Merle Ash  
Land Technologies, Inc.  
18820 3<sup>rd</sup> Avnue NE  
Arlington, WA 98223

Re: 163 RV – *Technical Review 1*  
PA 23016

After preliminary review of the above referenced proposal, the following comments have been prepared:

SU-40 Single Unit Track

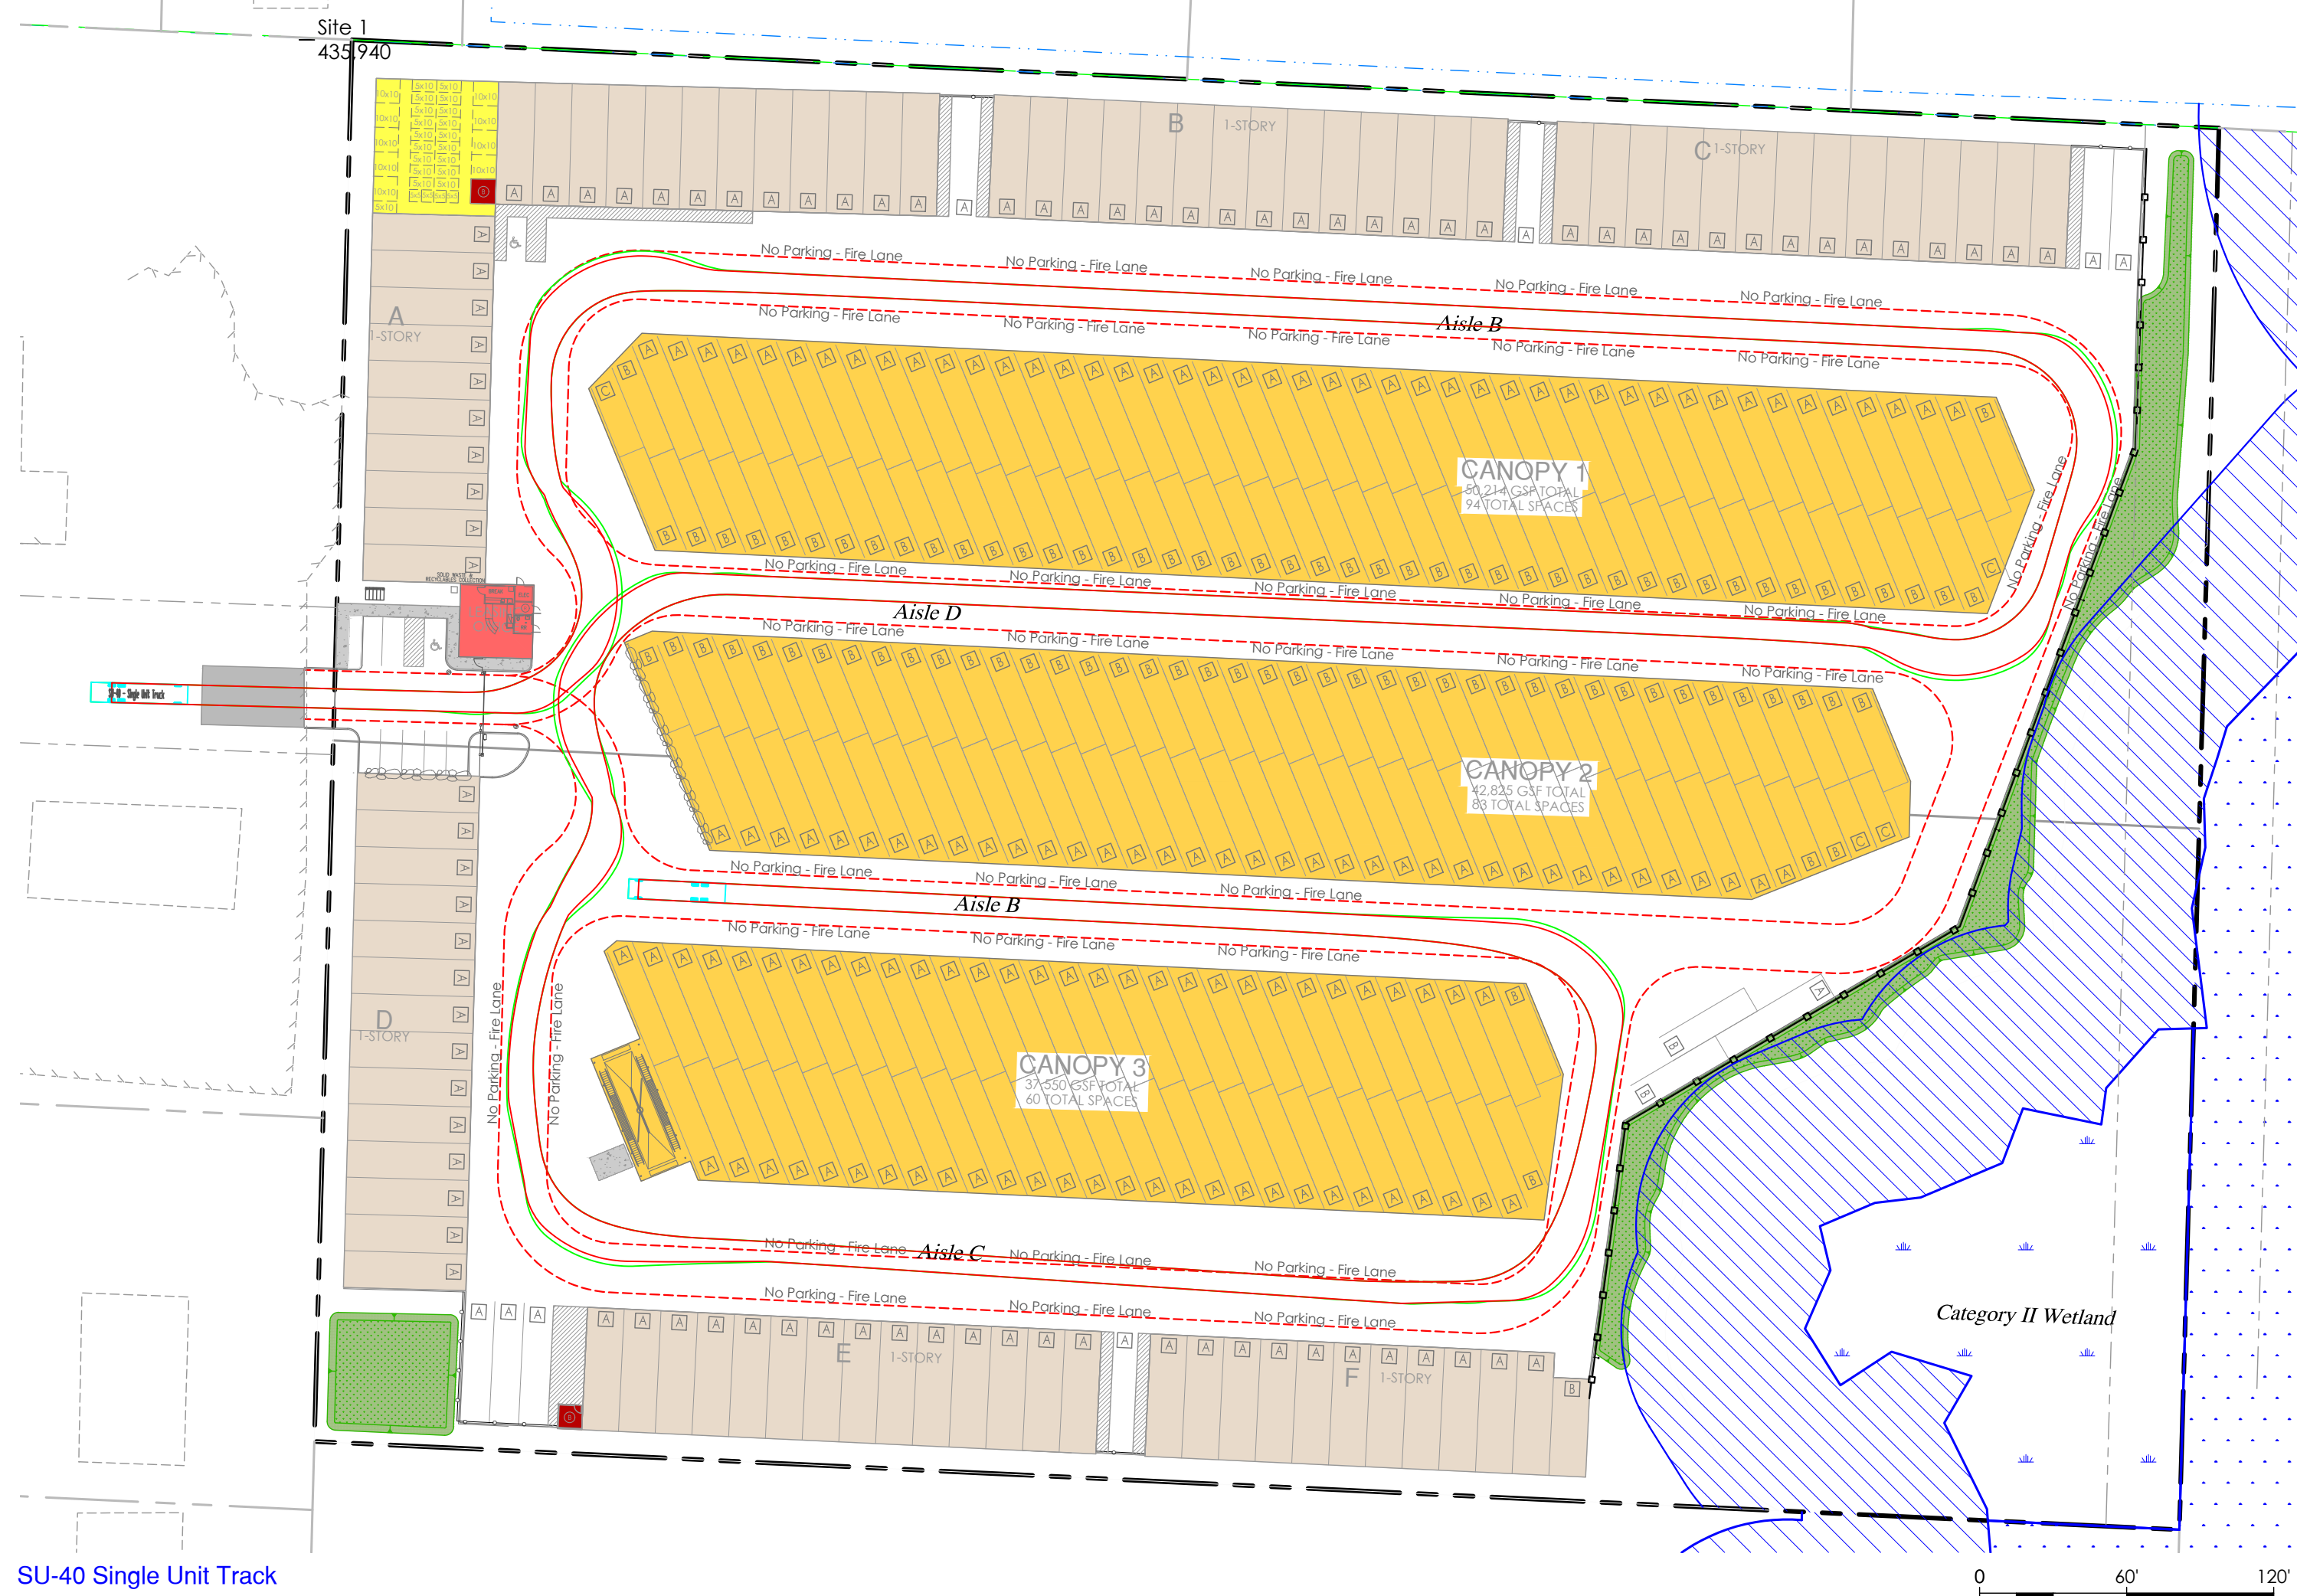
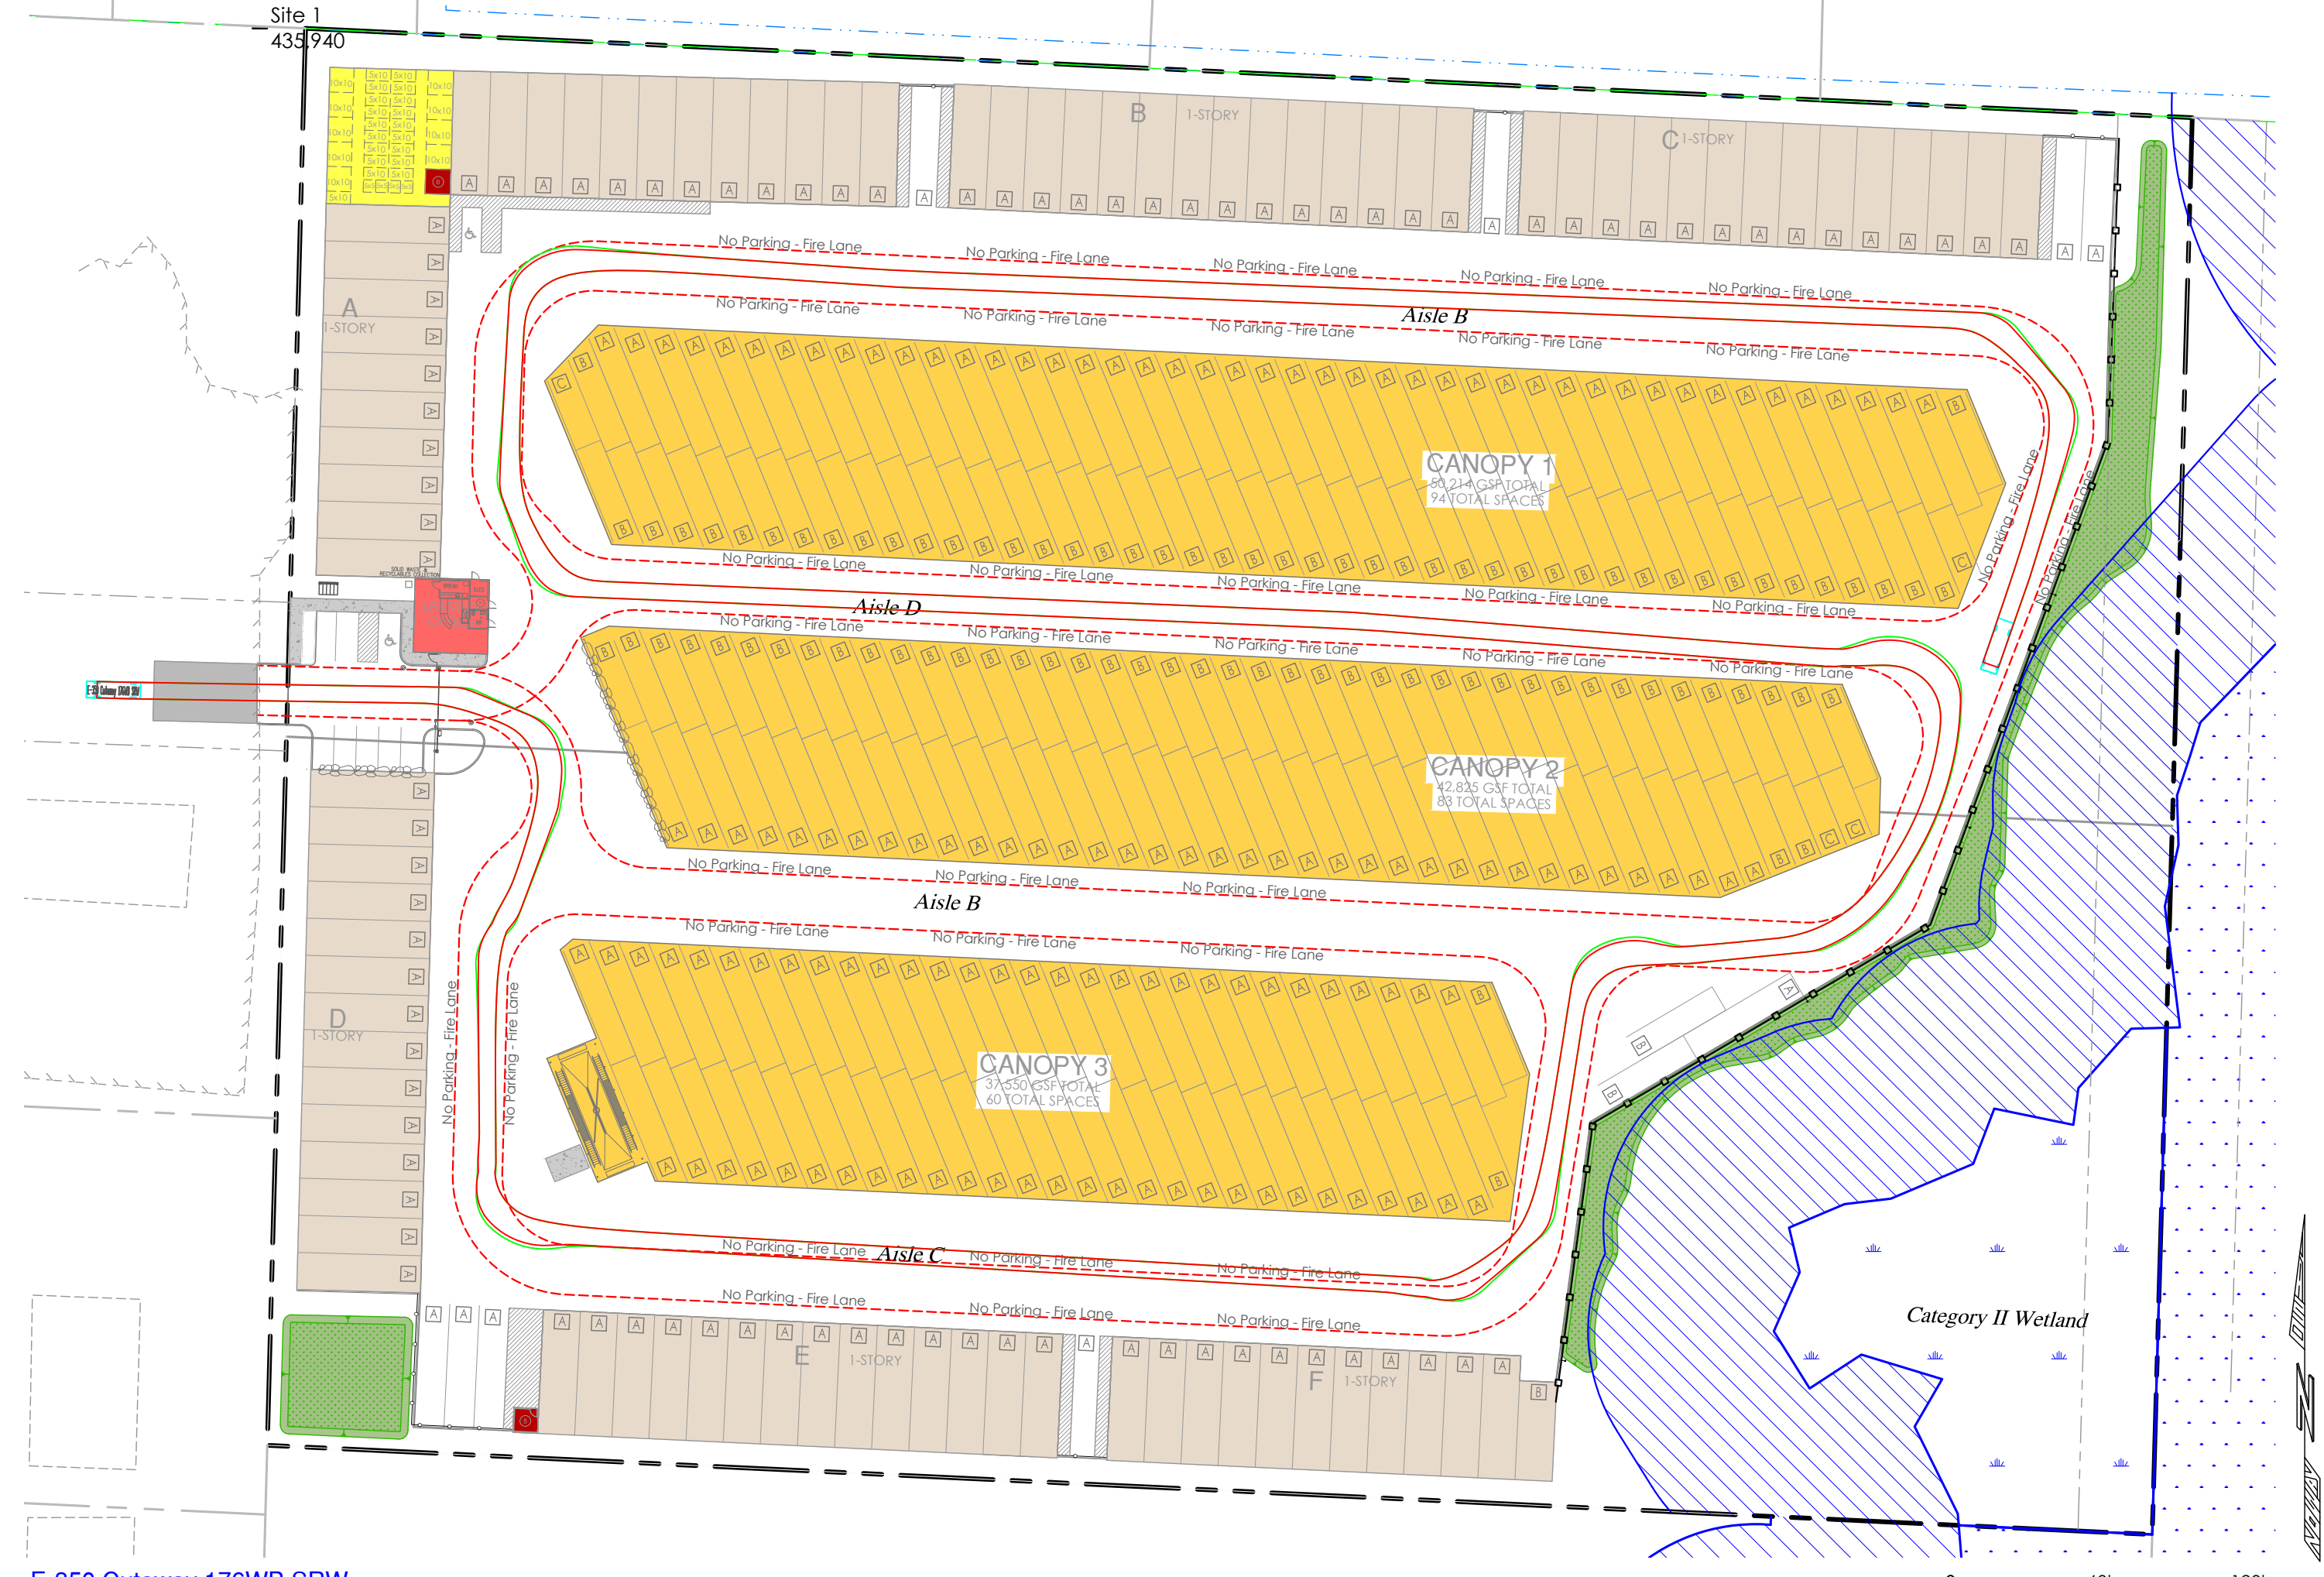
- g. Provide an auto-turn exhibit demonstrating the Emergency Service vehicles, RV's, trucks and trailers can navigate through the site.
7. The landscape plan shall be amended, as follows:
